Our ref: DOC26/139996-10

EPA Advice on Modification Application - MOD 16 - NTSF hydrocyclone sands buttressing - MP06_0295-Mod-16

Attachment A – NSW EPA detailed comments on Modification Report - MOD 16 - NTSF hydrocyclone sands buttressing - MP06_0295-Mod-16

Figure 3-1: Compliance Noise Monitoring Locations - Cadia Valley Operations

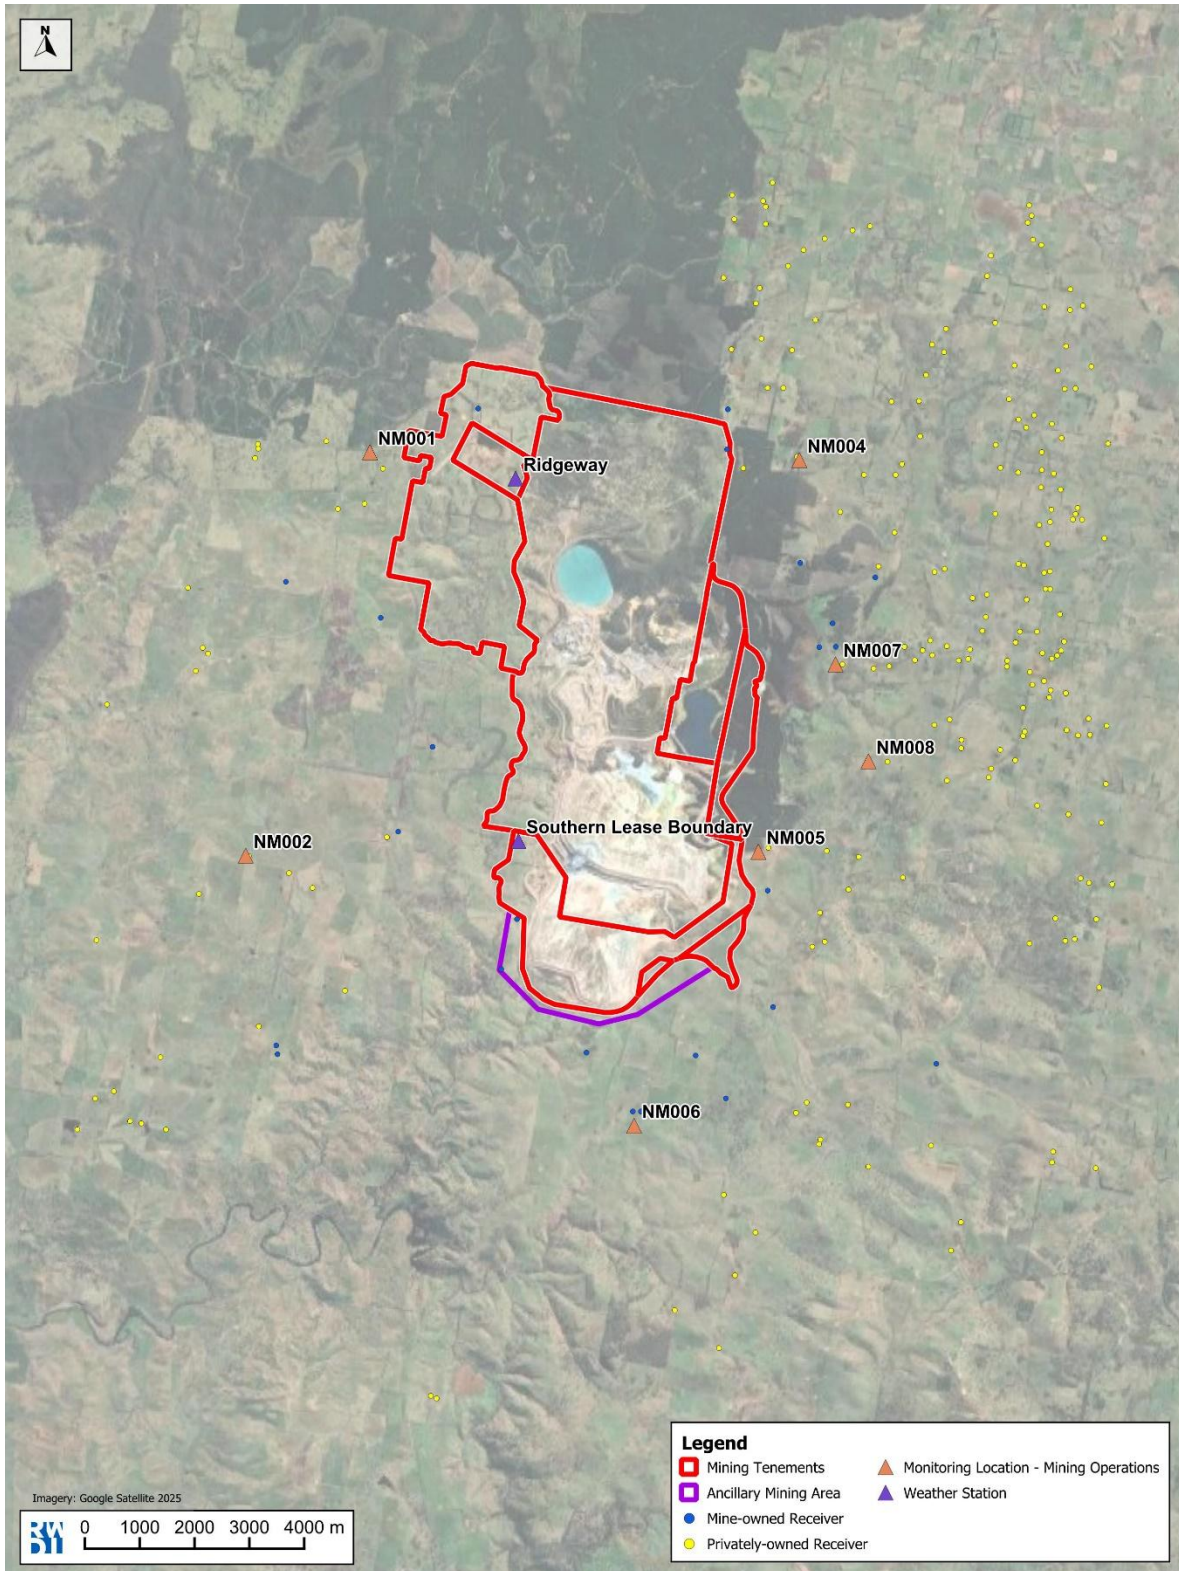
- a) Modify and implement the Trigger Action Response Plan and Noise Management Plan to include measures and protocols that ensure compliance with the noise limits under all applicable meteorological and operating conditions; and
- b) Review and confirm or modify, as appropriate, noise monitoring locations in the Trigger Action Response Plan and Noise Management Plan.
